PINE VIEW ESTATES FILING NO. 1

STREET PLANS

TITLE SHEET	1 OF 3
STREET IMPROVEMENT PLAN & PROFILE	2 OF 3
RED BARN ROAD	3 OF 3
STREET IMPROVEMENT PLAN - CUL-DE-SAC-FLOWLINE PLAN & PROFILE

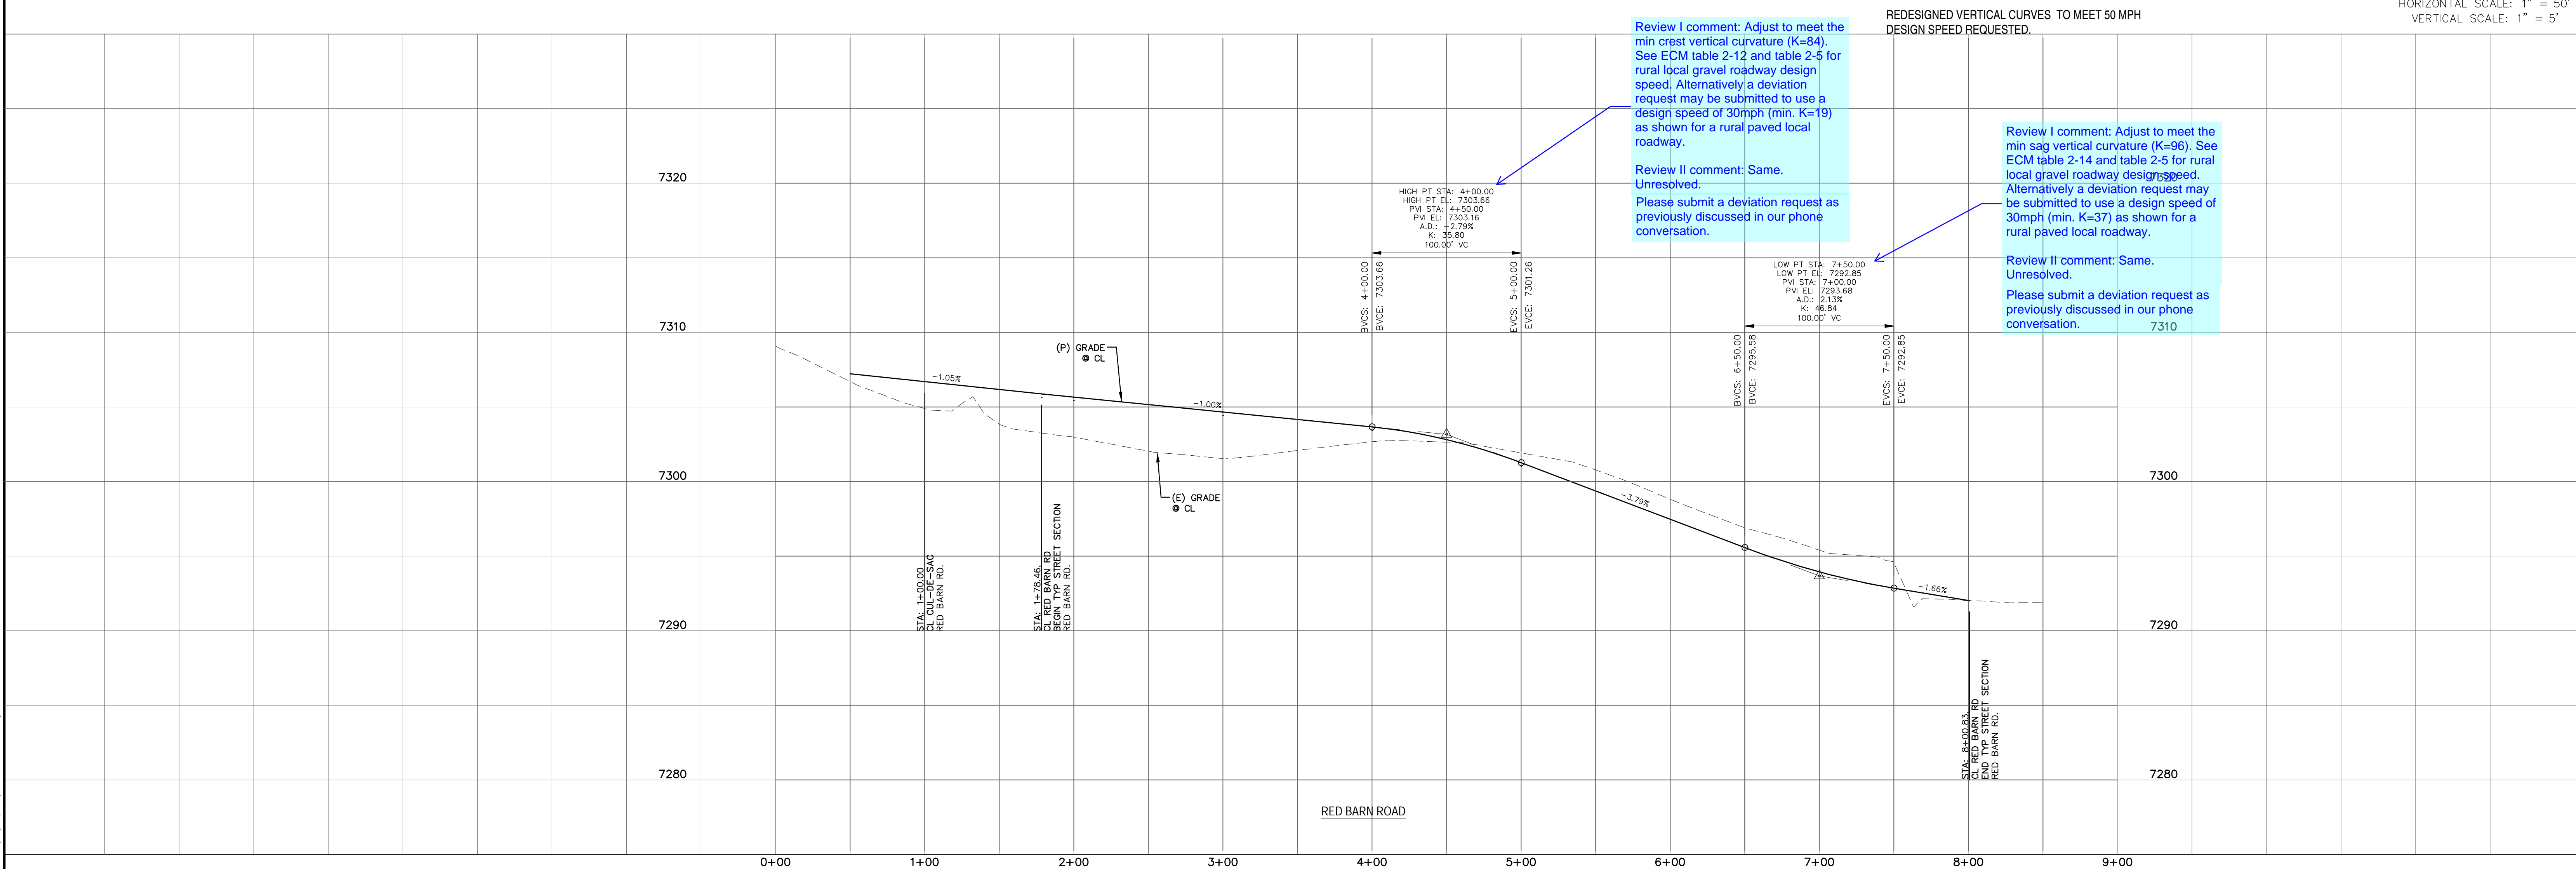
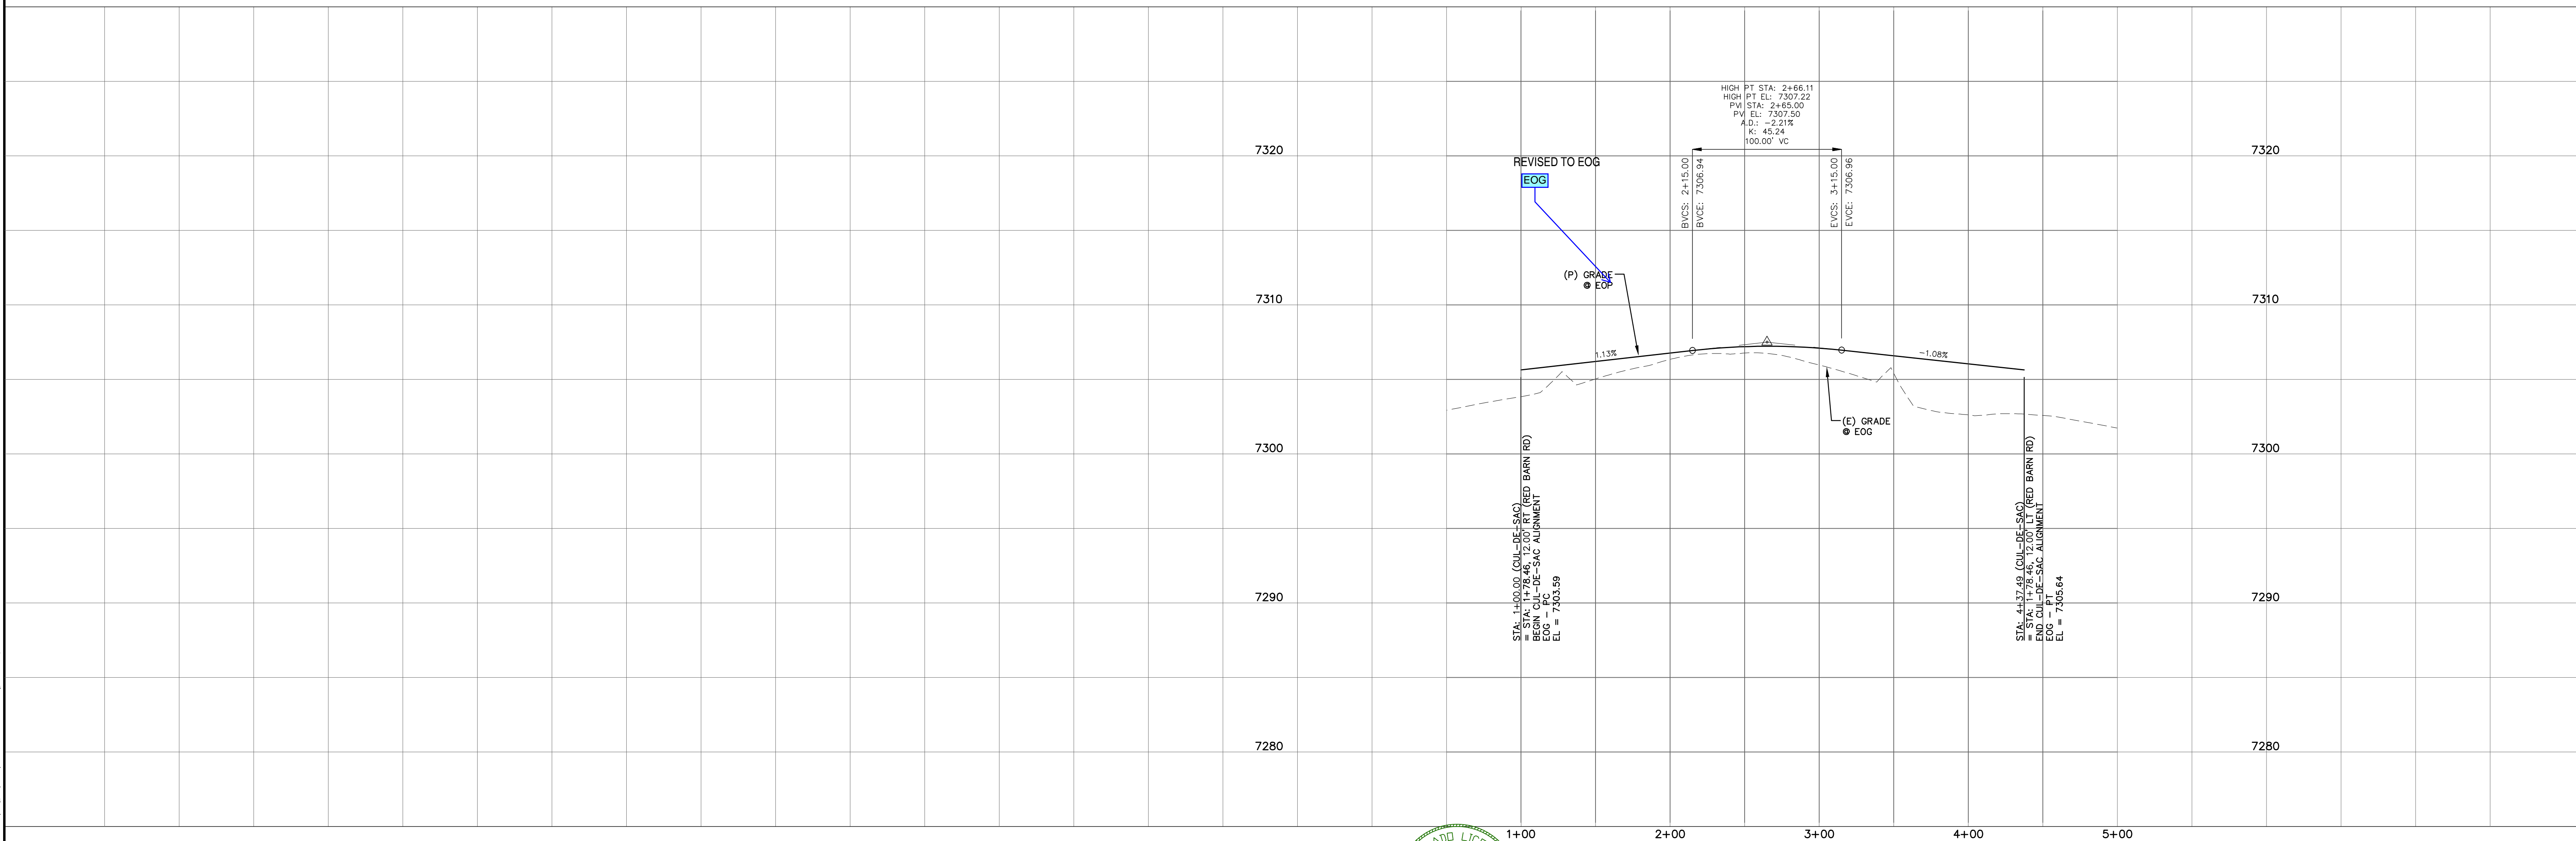
Review I comment: Adjust to meet the min crest vertical curvature (K=84). See ECM table 2-12 and table 2-5 for rural local gravel roadway design speed. Alternatively a deviation request may be submitted to use a design speed of 30mph (min. K=19) as shown for a rural paved local roadway.

Review II comment: Same. Unresolved. Please submit a deviation request as previously discussed in our phone conversation.

Review I comment: Adjust to meet the min sag vertical curvature (K=96). See ECM table 2-14 and table 2-5 for rural local gravel roadway design speed. Alternatively a deviation request may be submitted to use a design speed of 30mph (min. K=37) as shown for a rural paved local roadway.

Review II comment: Same. Unresolved. Please submit a deviation request as previously discussed in our phone conversation.
